RE: SITE PLAN – ADMINISTRATIVE DEVELOPMENT FACILITATION TEAM
PR-2024-010691, SP-2025-00031
7520 RAINBOW BLVD NW; LT 11-A BLK 2 PLAT OF LTS 10-A, 11-A, 19-A THRU 22-A BLK
2UNIT 14 VOLCANO CLIFFS SUBD CONT 2.0312 AC

Please see responses to DFT comments for **PR-2024-010691**, **SP-2025-00031**. Also included are the updated construction drawings to address the comments.

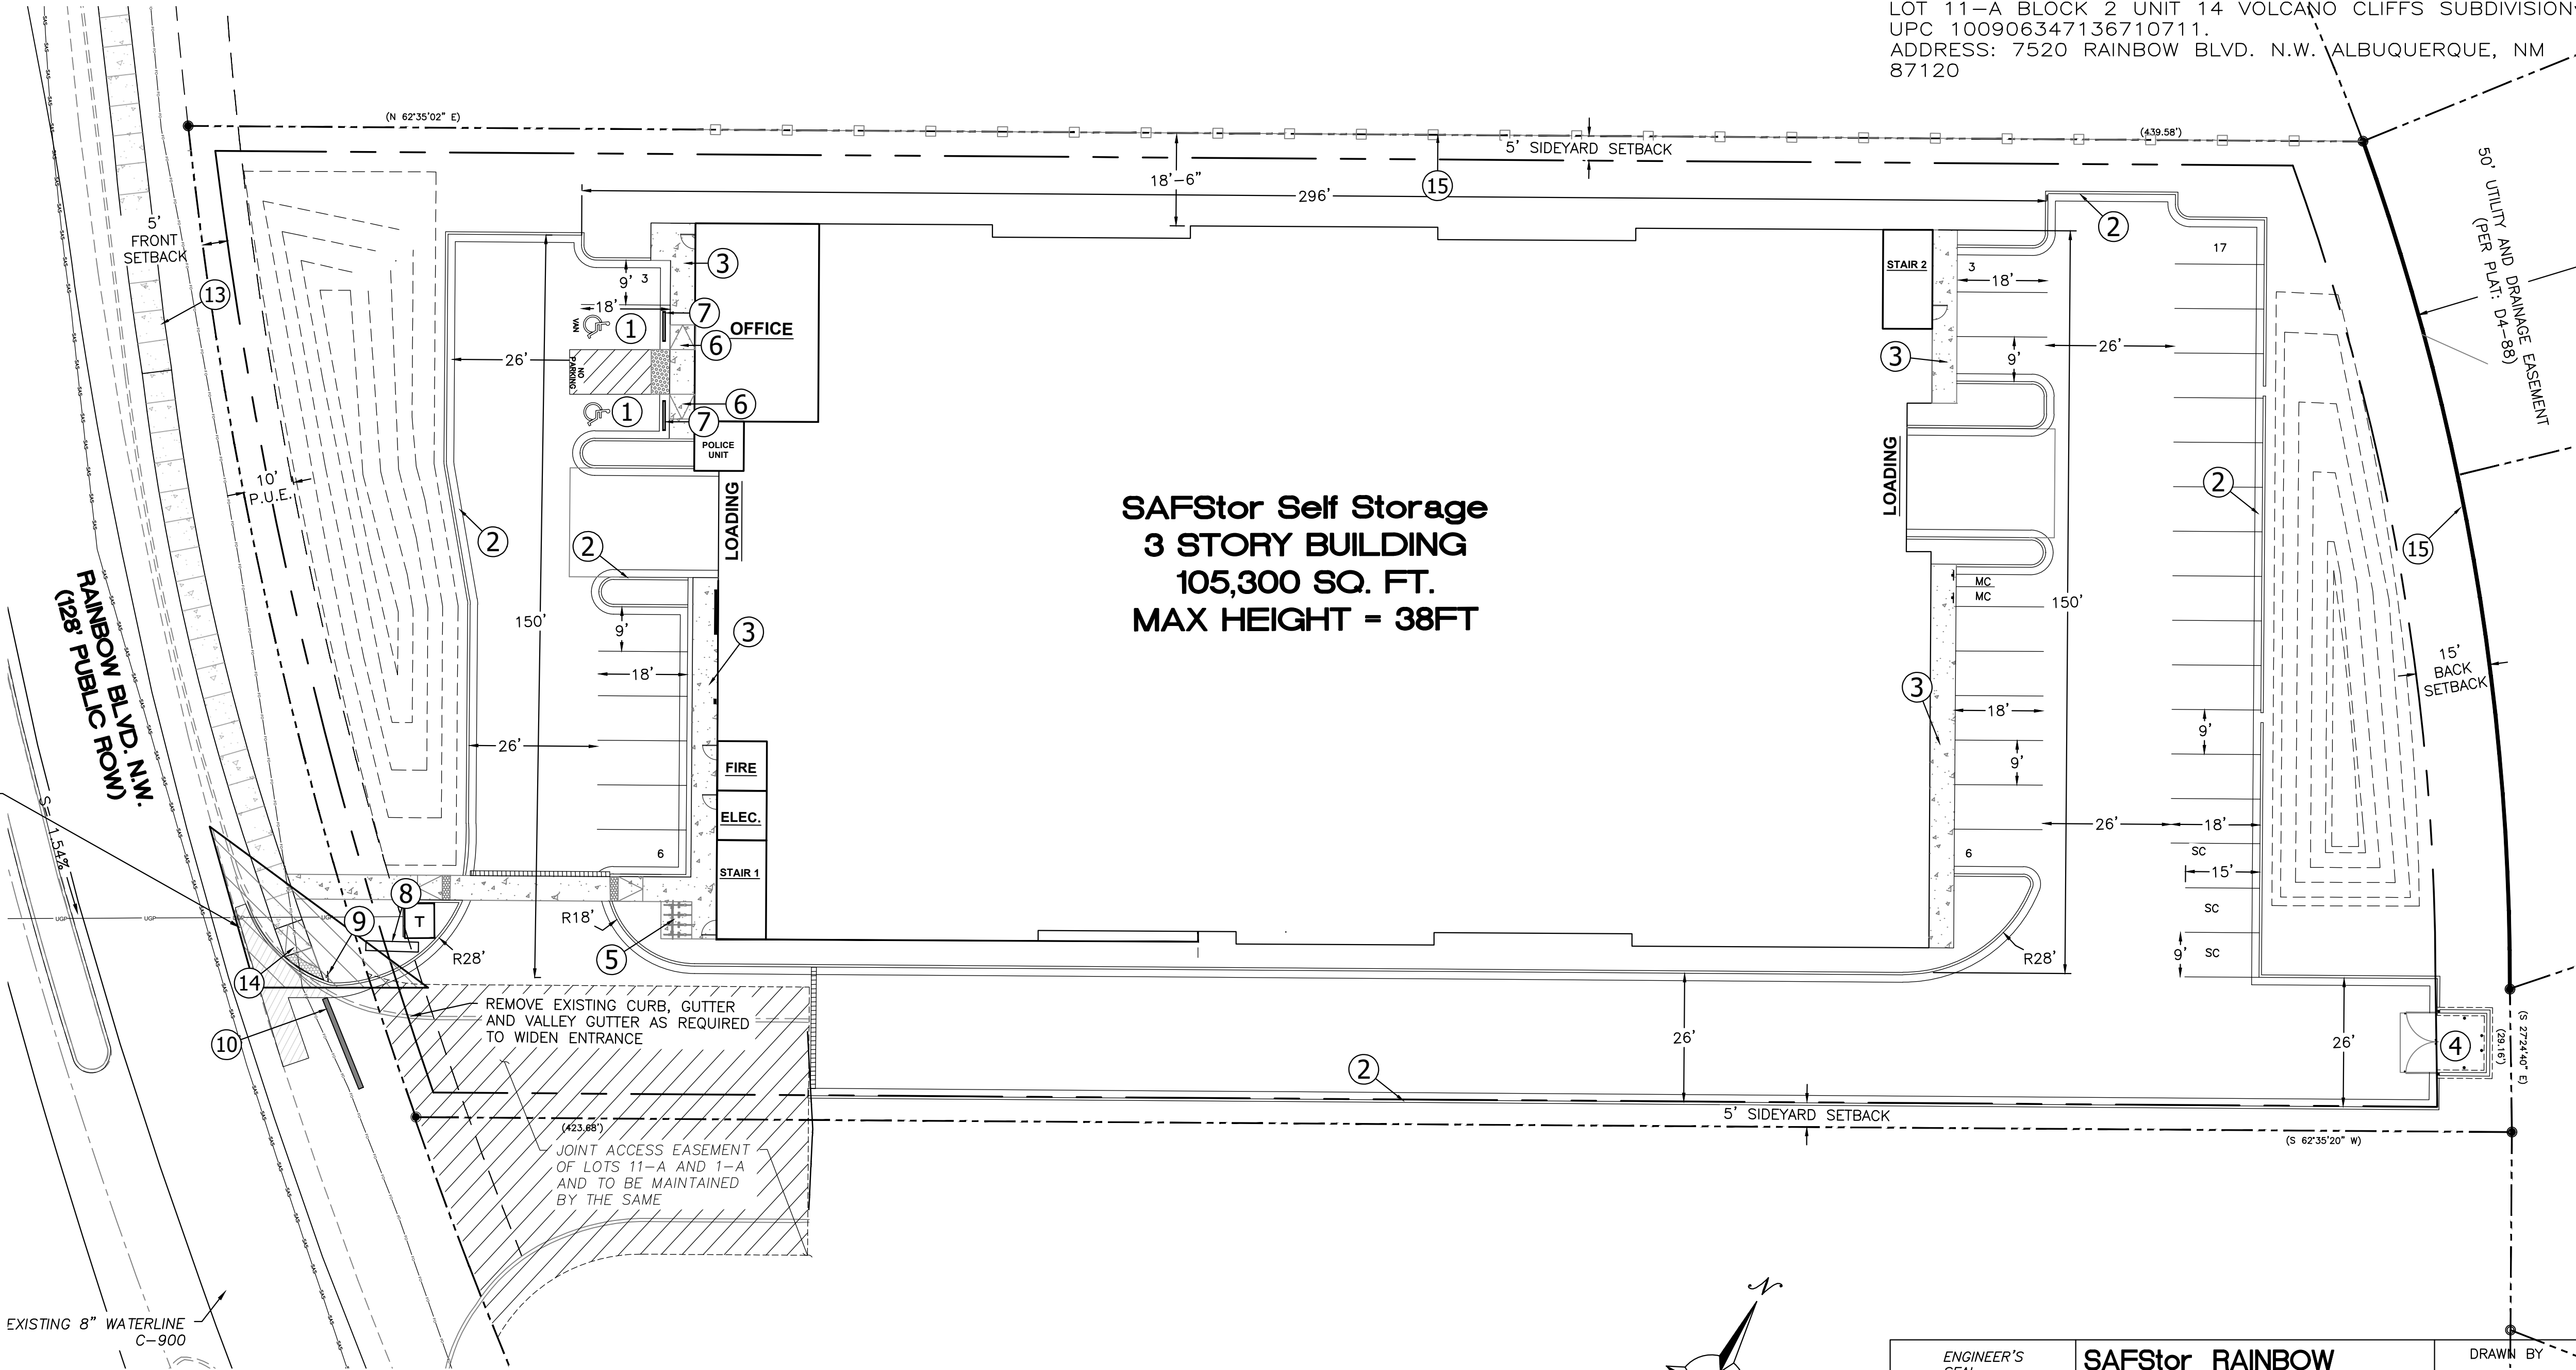
- 1. The Infrastructure list (IL) must be signed/executed by Ron Bohannan.
 - RESPONSE: IL has been updated and signed/executed by Ron Bohannan.
- 2. Rainbow Blvd. is a Principal Arterial Street and required 6' sidewalk width a 5' to 6' landscape buffer. Please provide a dimension of sidewalks and buffers along the frontage.

- RESPONSE: Site Plan and Landscaping Plans have been updated to identify the sidewalk and buffer dimensions along the frontage.
- 3. Provide a lighting plan with dimensions that meets IDO section 4-3-d-29, and section 5-8.

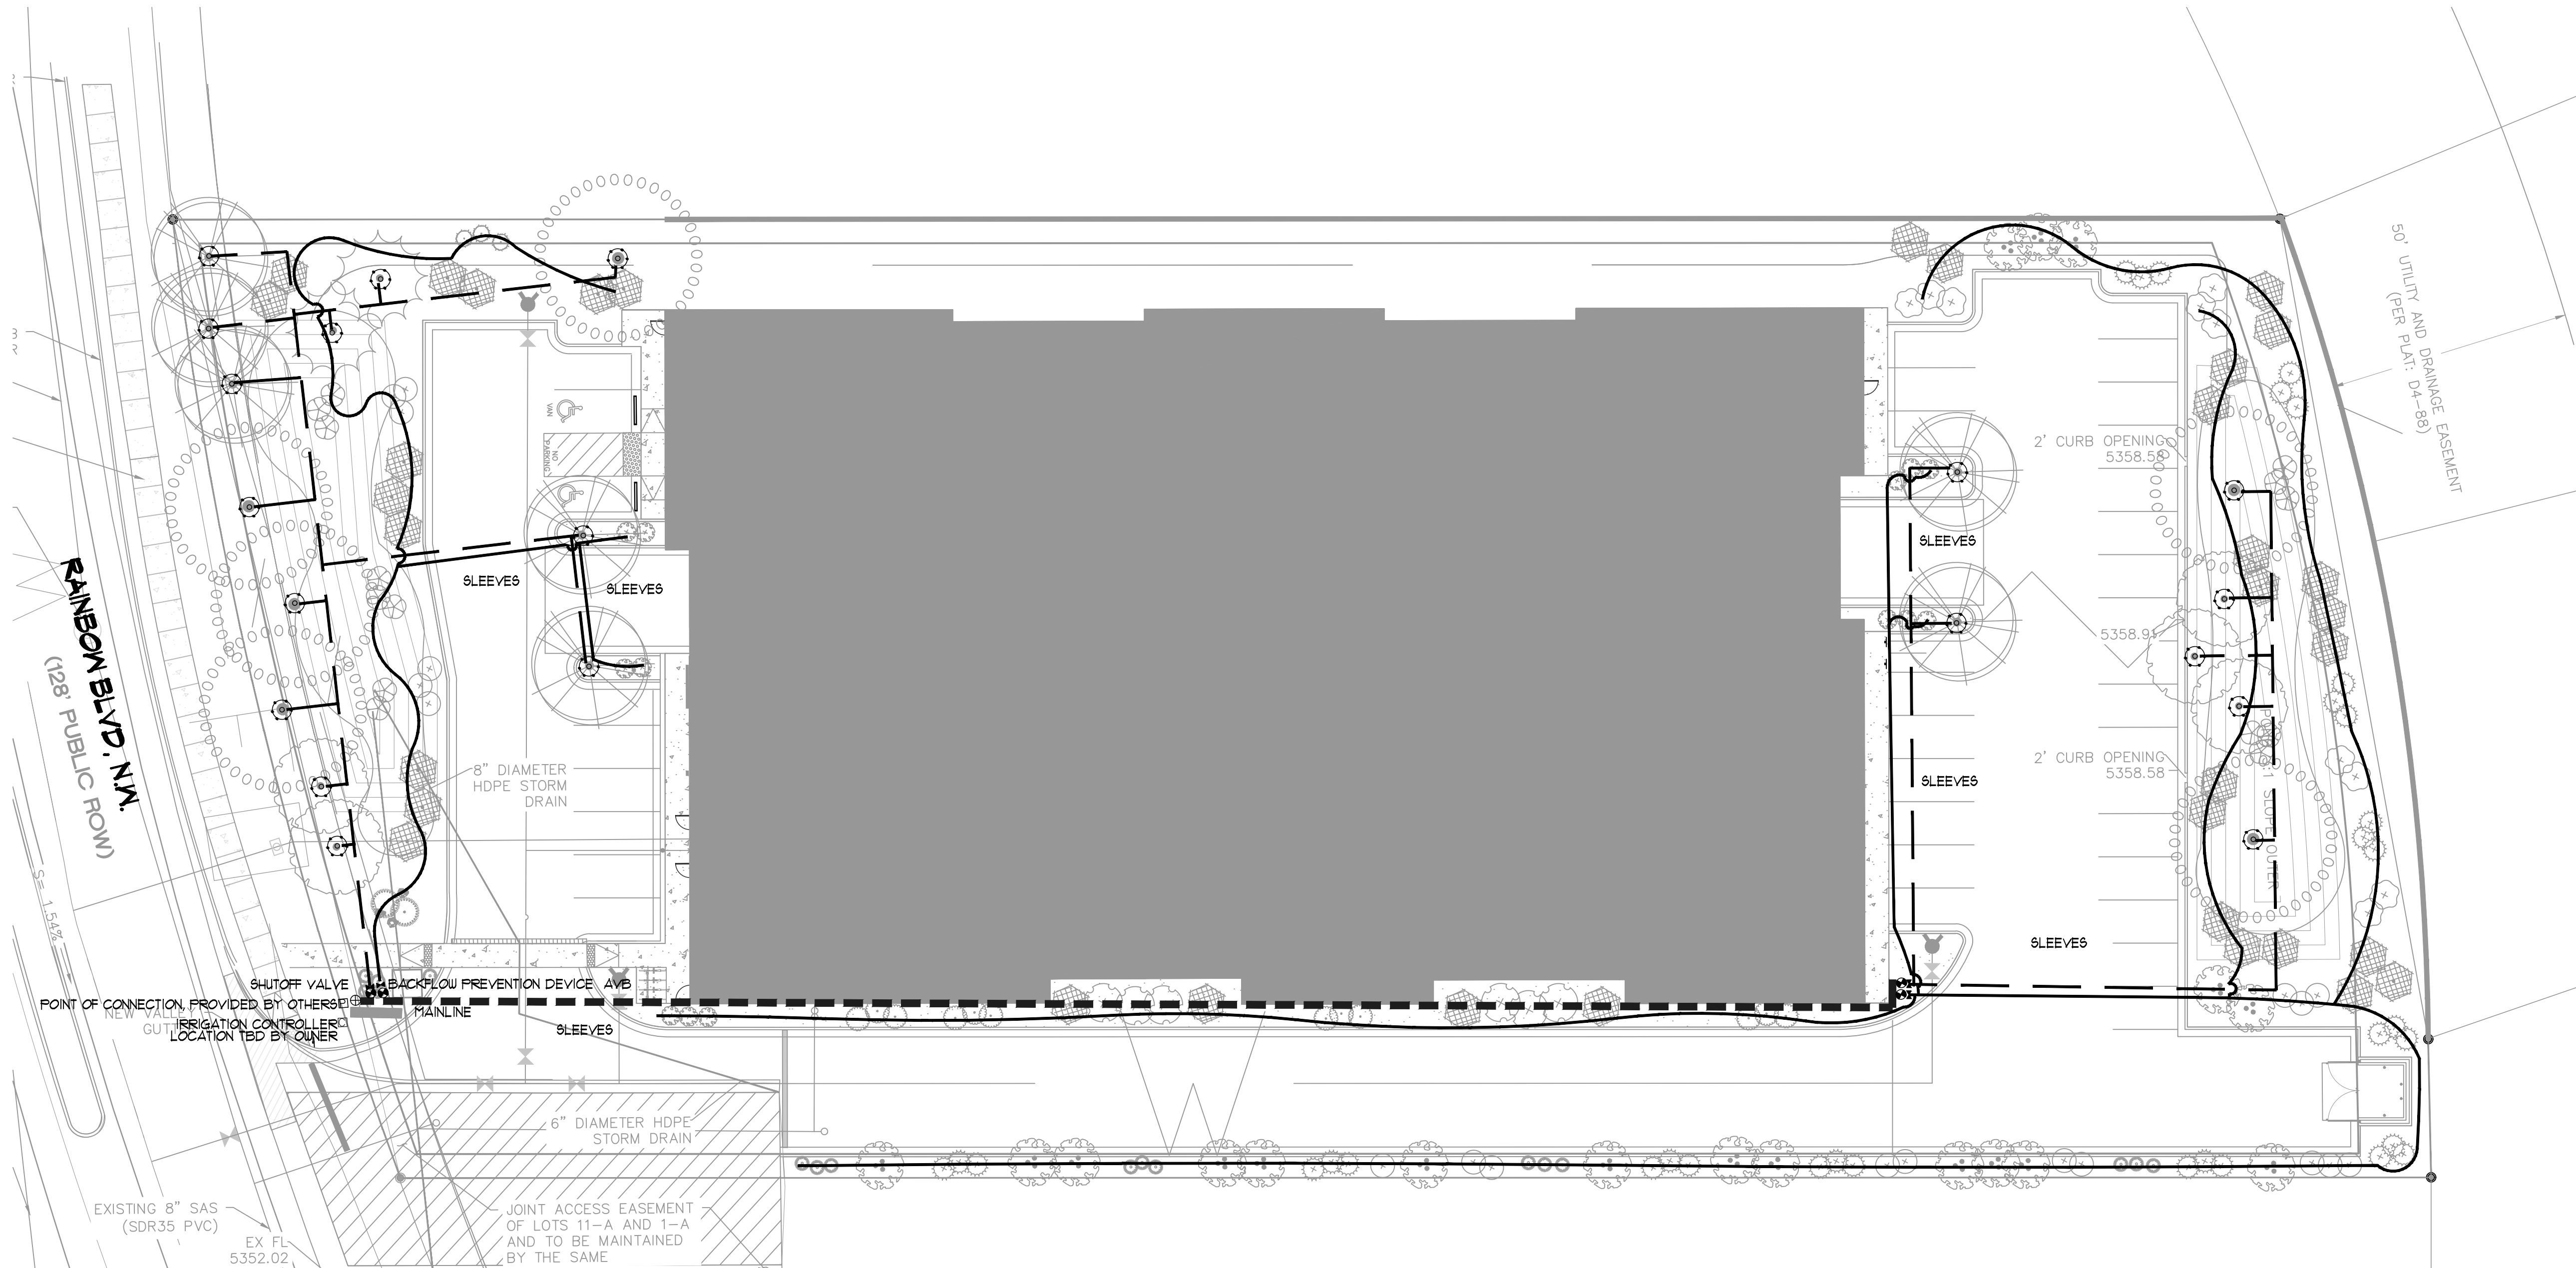
- 1. Street trees must be spaced 25 feet on center (O.C.) as required by Park and Recreation. **RESPONSE: Landscaping Plans have been updated to reflect this spacing requirement.**
- 2. According to IDO 5-6(C)(7)(e), trees must also be spaced so that no tree is planted within half the mature canopy diameter of another tree.

- 3. Please verify that the proposed spacing is not too tight and meets both spacing requirements. **RESPONSE: Verified.**
- 4. Pinon Pines are only conditionally recommended and are not suitable for commercial applications. Please select a different species.
 - RESPONSE: Landscaping Plans have been updated to remove the Pinon Pines accordingly.
- 5. Update the tree planting detail to indicate that organic mulch should not be placed directly at the base of the tree.
 - **RESPONSE:** Landscaping Plans have been updated to reflect this detail.
- 6. A multi-use trail is planned for future development across the subject property.

RESPONSE: Acknowledged. Tree's along frontage have been staggered to accommodate this requirement.

SAFStor RAINBOW
ALBUQUERQUE, N.M.
MASTER UTILITY
PLAN

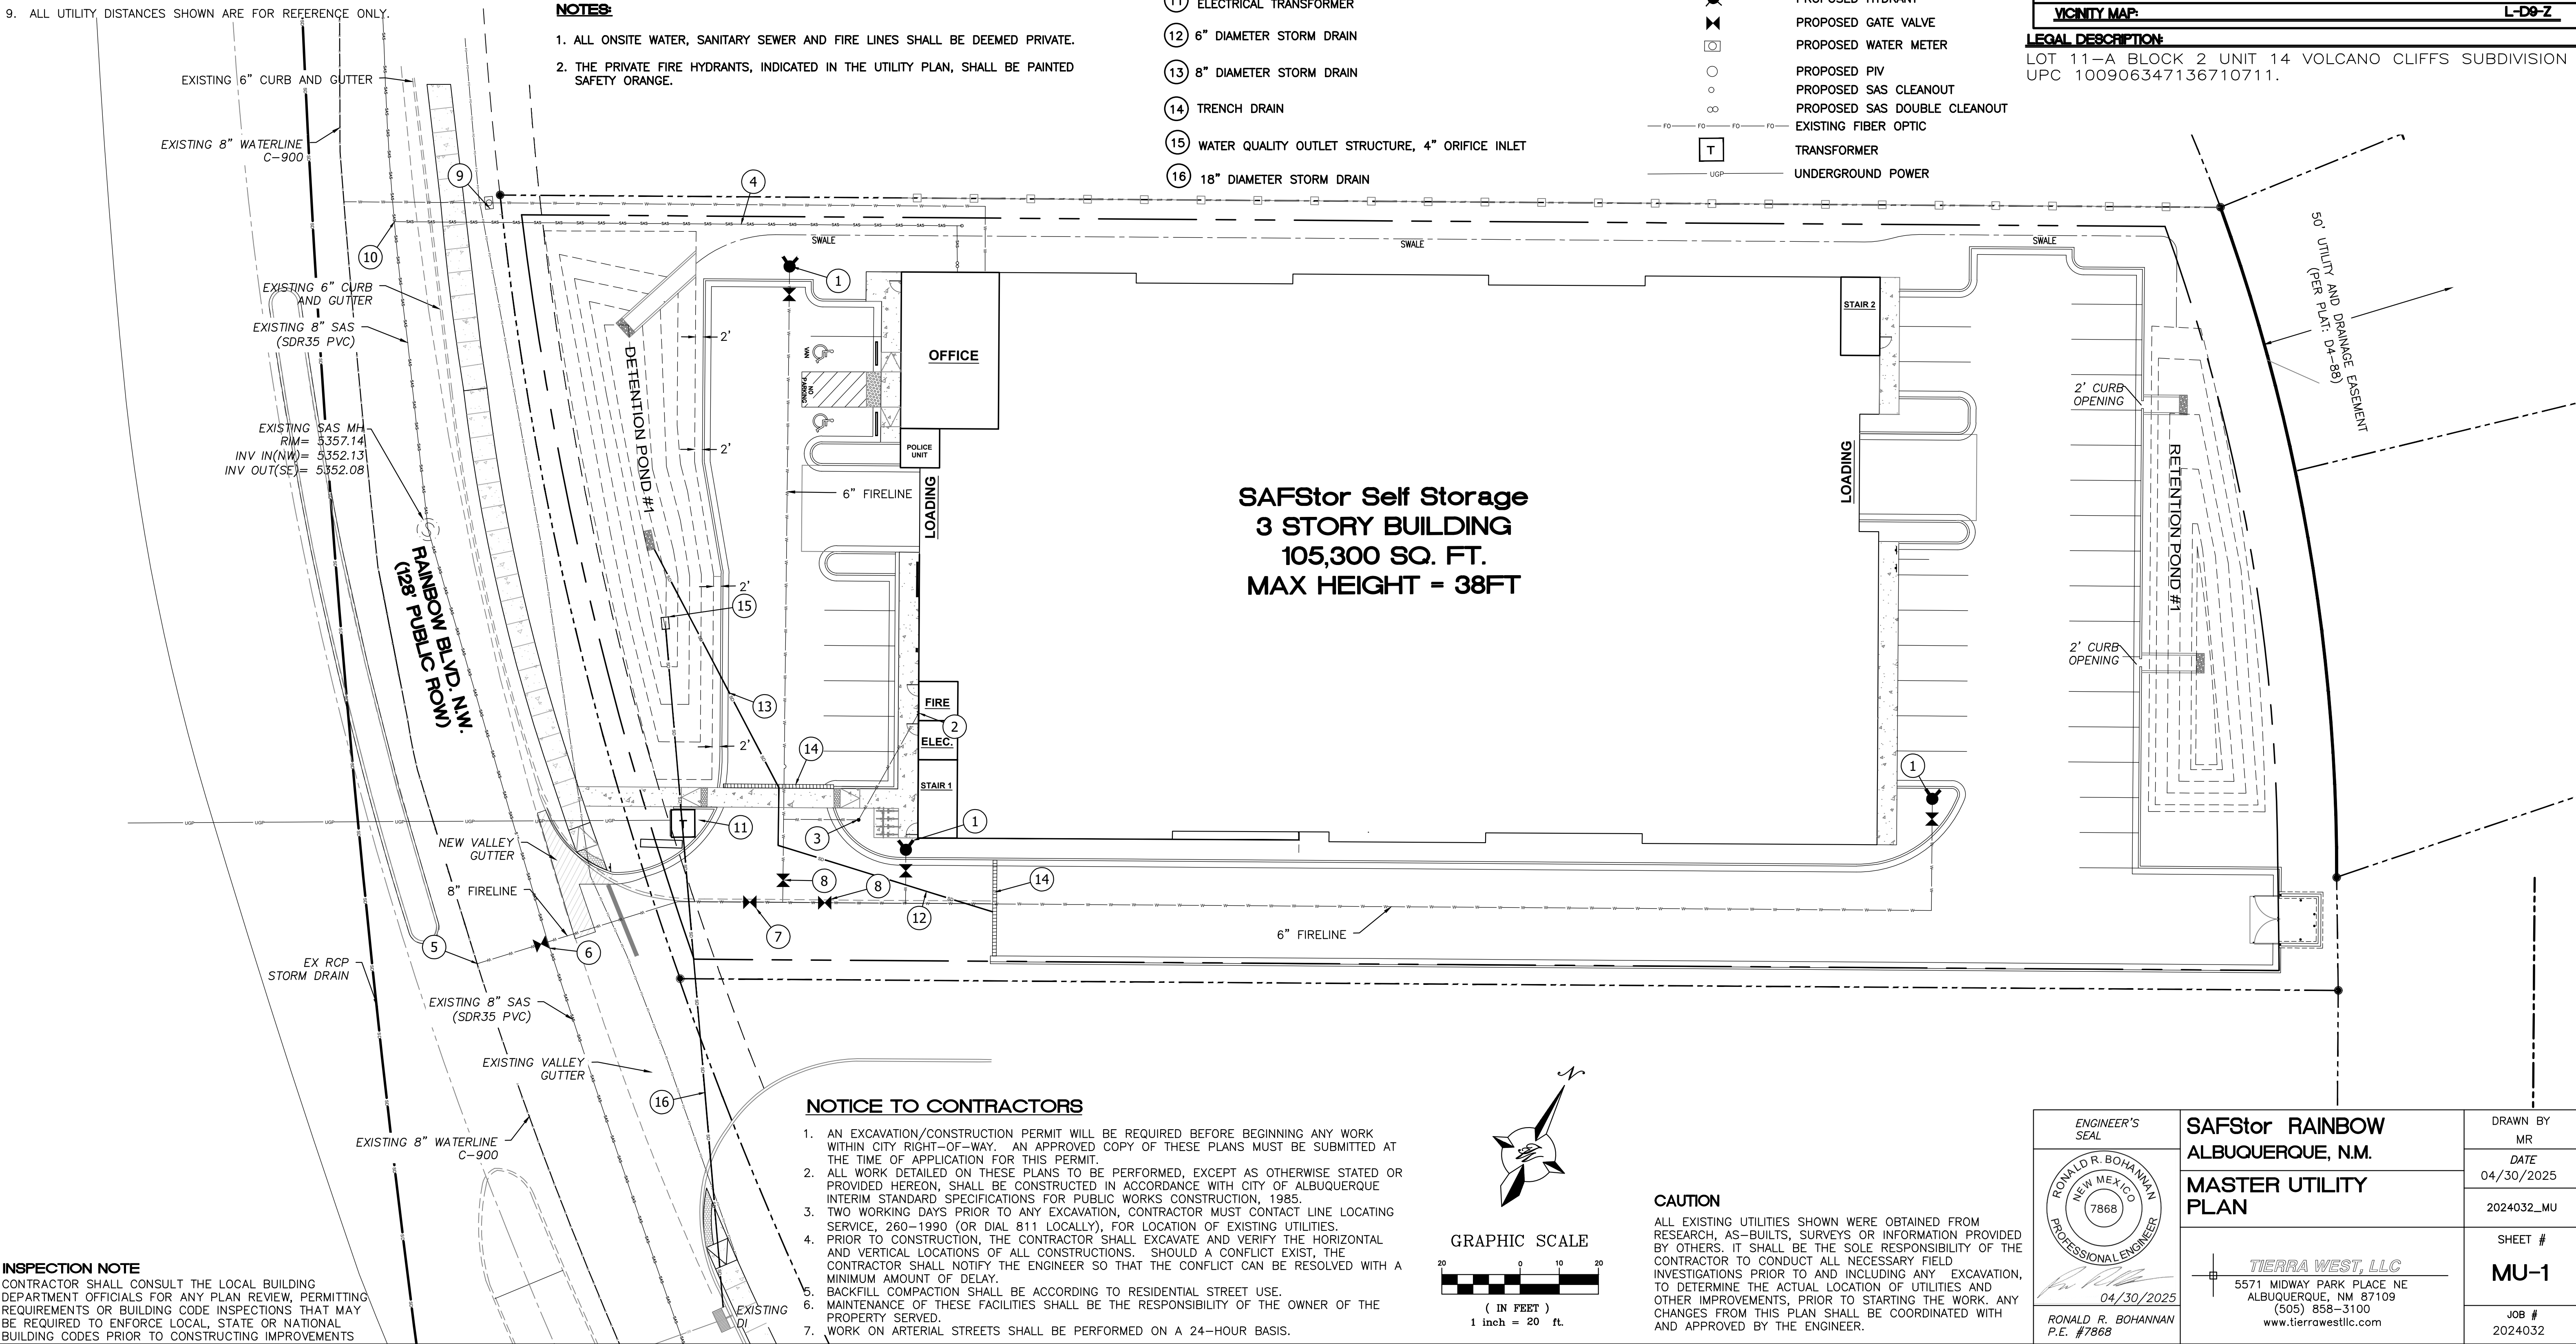
- 2. Please label the portion of public fire line within the right-of-way as "public" and note that it will be constructed with a work order or connection permit (as applies) as well as any other connections to the public water and/or sanitary sewer systems.

- 4. Please add the following notes to the Master Utility Plan
 - a. Coordination with Water Authority Cross Connection Section will be required to ensure proper backflow containment is in place prior to release of meter for the site. Contact the Cross Connection Section at 505-289-3454.

- b. Coordination with the Water Authority Pre-Treatment Engineer is required to ensure the site complies with Water Authority Sewer Use Ordinance. Contact the Pre-Treatment Engineer at 505-289-3439.

- **RESPONSE:** This has been labeled. See updated MUP.
- 3. Due to a pending Request for Availability, the site plan proposed cannot yet be approved. RESPONSE: Acknowledged. Availability Statement 21017 was executed and approved on 8/12/2025.

RESPONSE: These notes have been included in the Master Utility Plan. See updated MUP. CODE ENFORCEMENT:
